December 30, 2022

Re: Alameda West
10127 Coors Blvd. NW
90-Day Temporary Certificate of Occupancy
Transportation Development Final Inspection
Architect's Stamp dated 10-10-22 (B14-D001B)
Certification dated 12-29-22

Project: Alameda West PR-2021-005687; SI-2022-00316

A-201

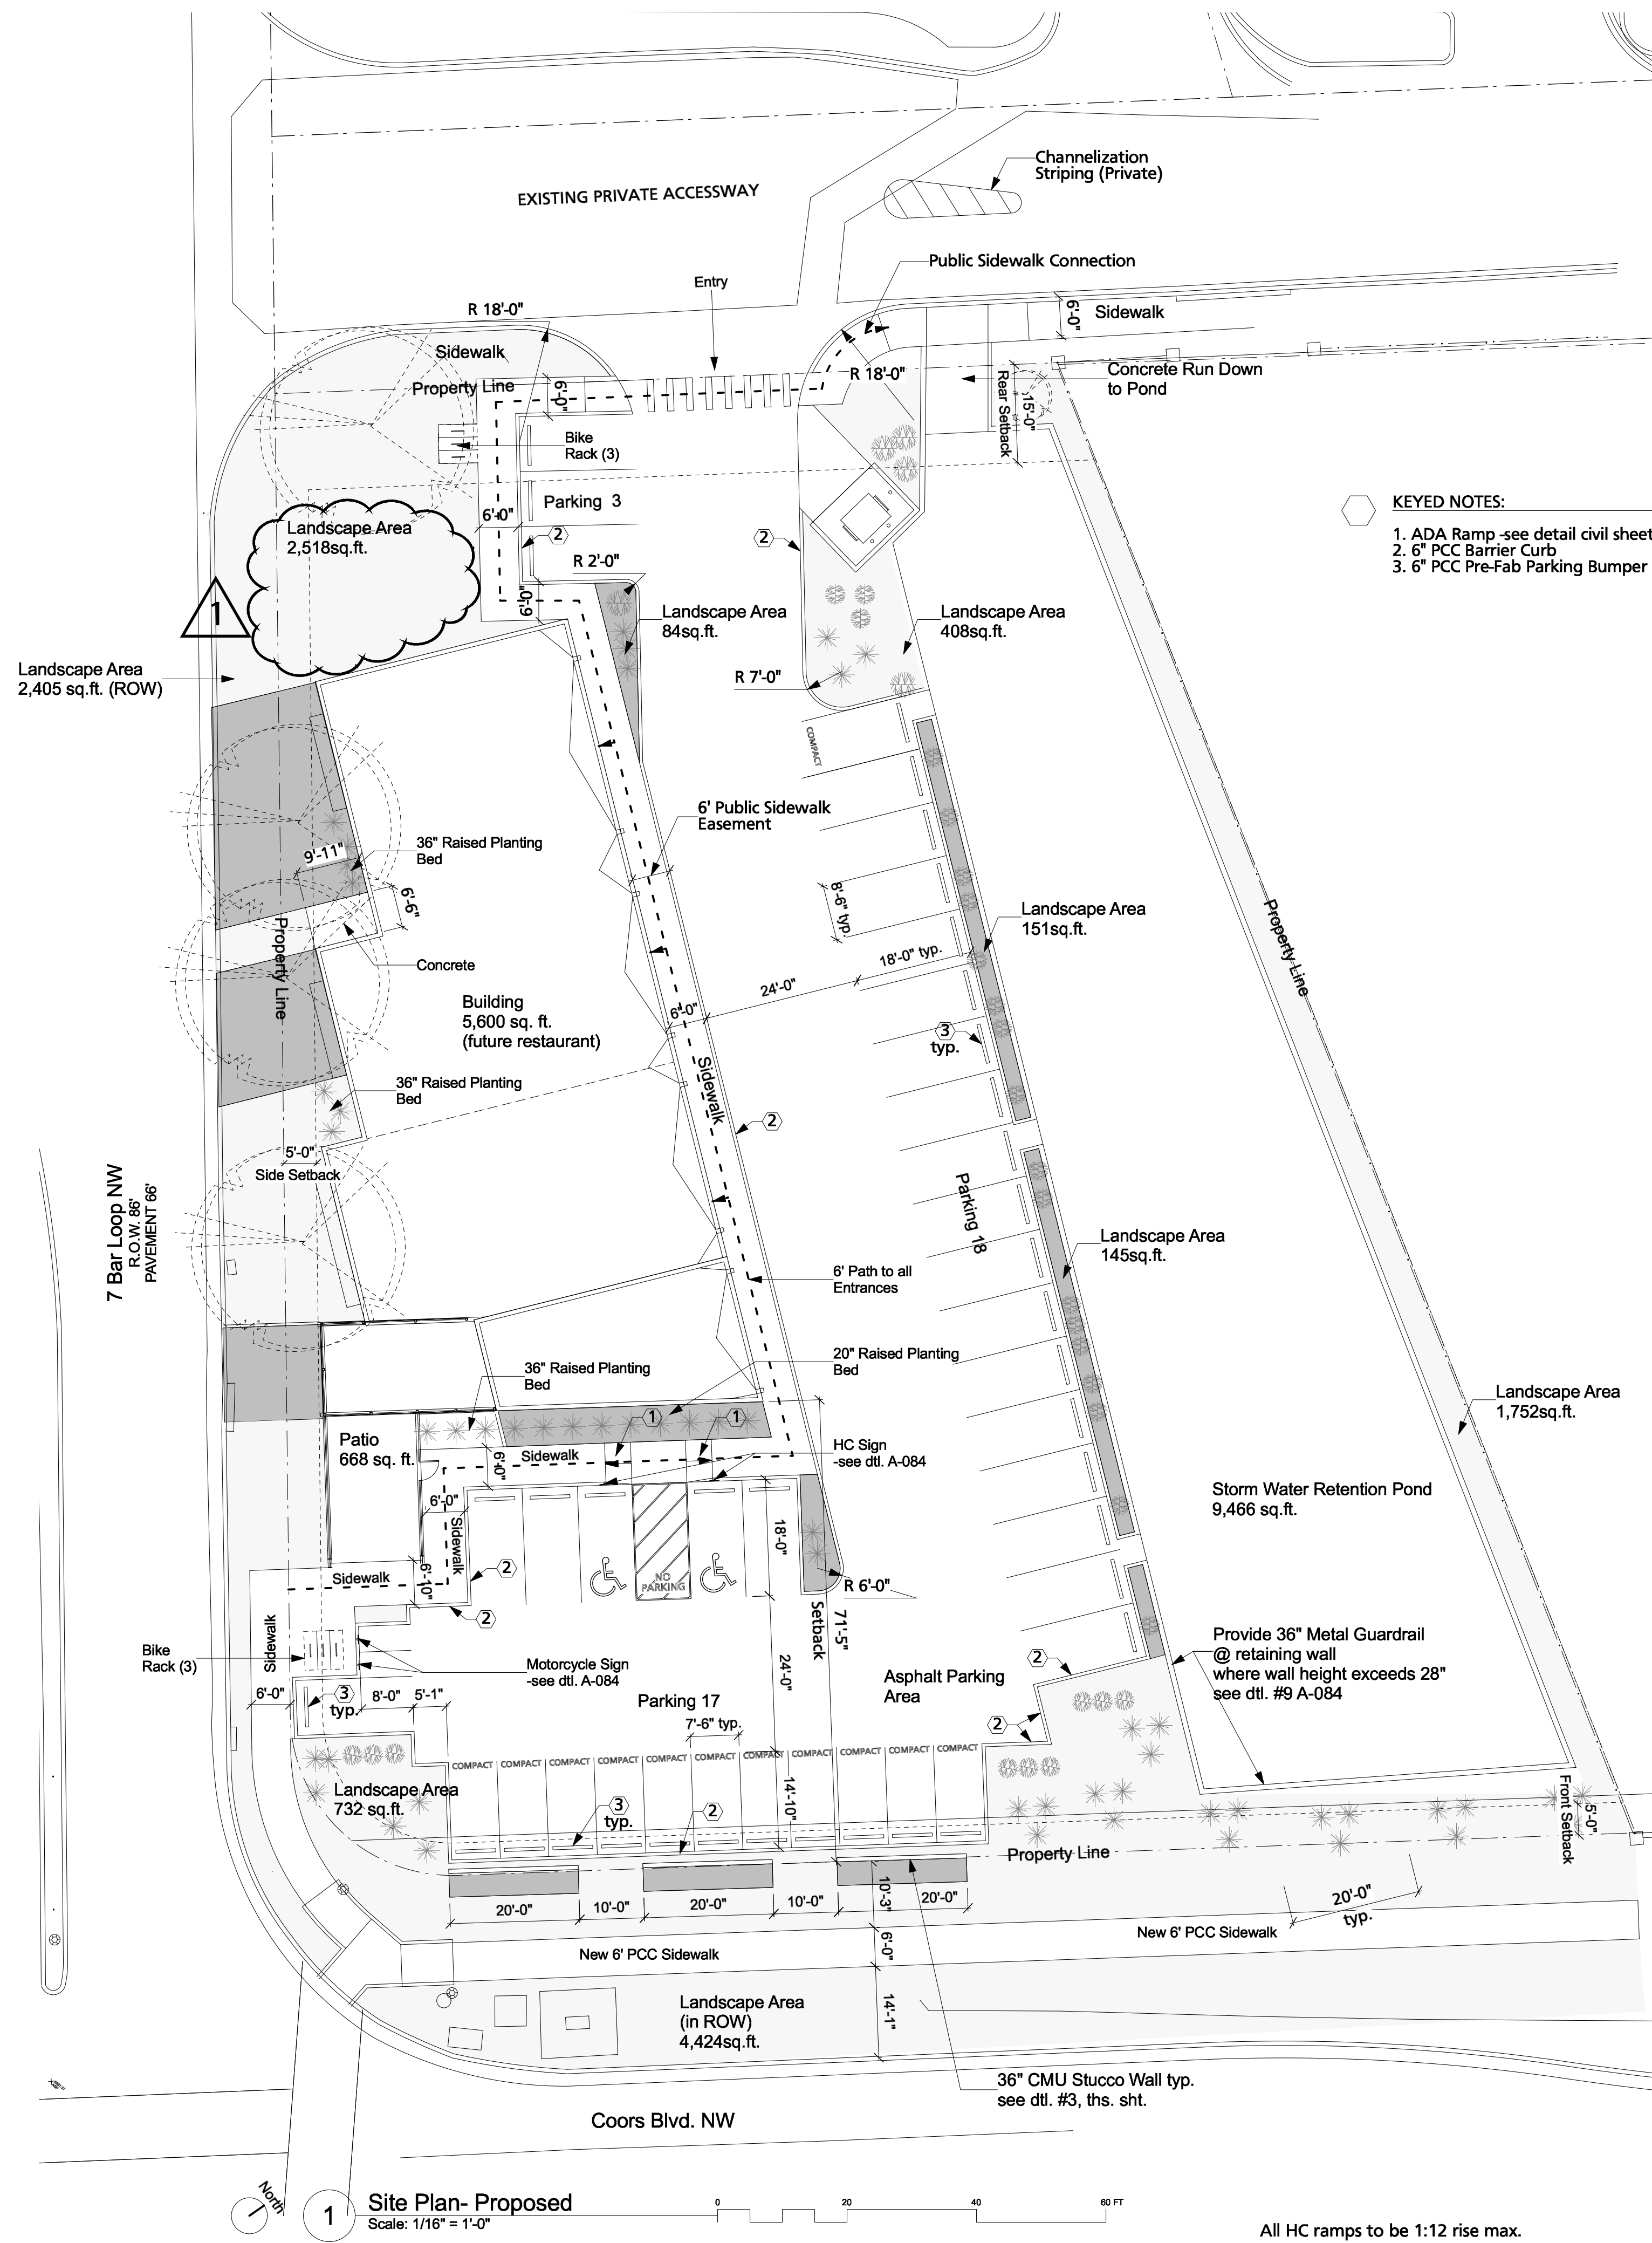
- Install sidewalk along 7-Bar Loop.
- The pavement marking "MC" should be shown in the opposite direction for motorcycles entering the parking space.
- Install sidewalk, curb, and ADA ramp off Coors Blvd. per approved NM DOT plans.
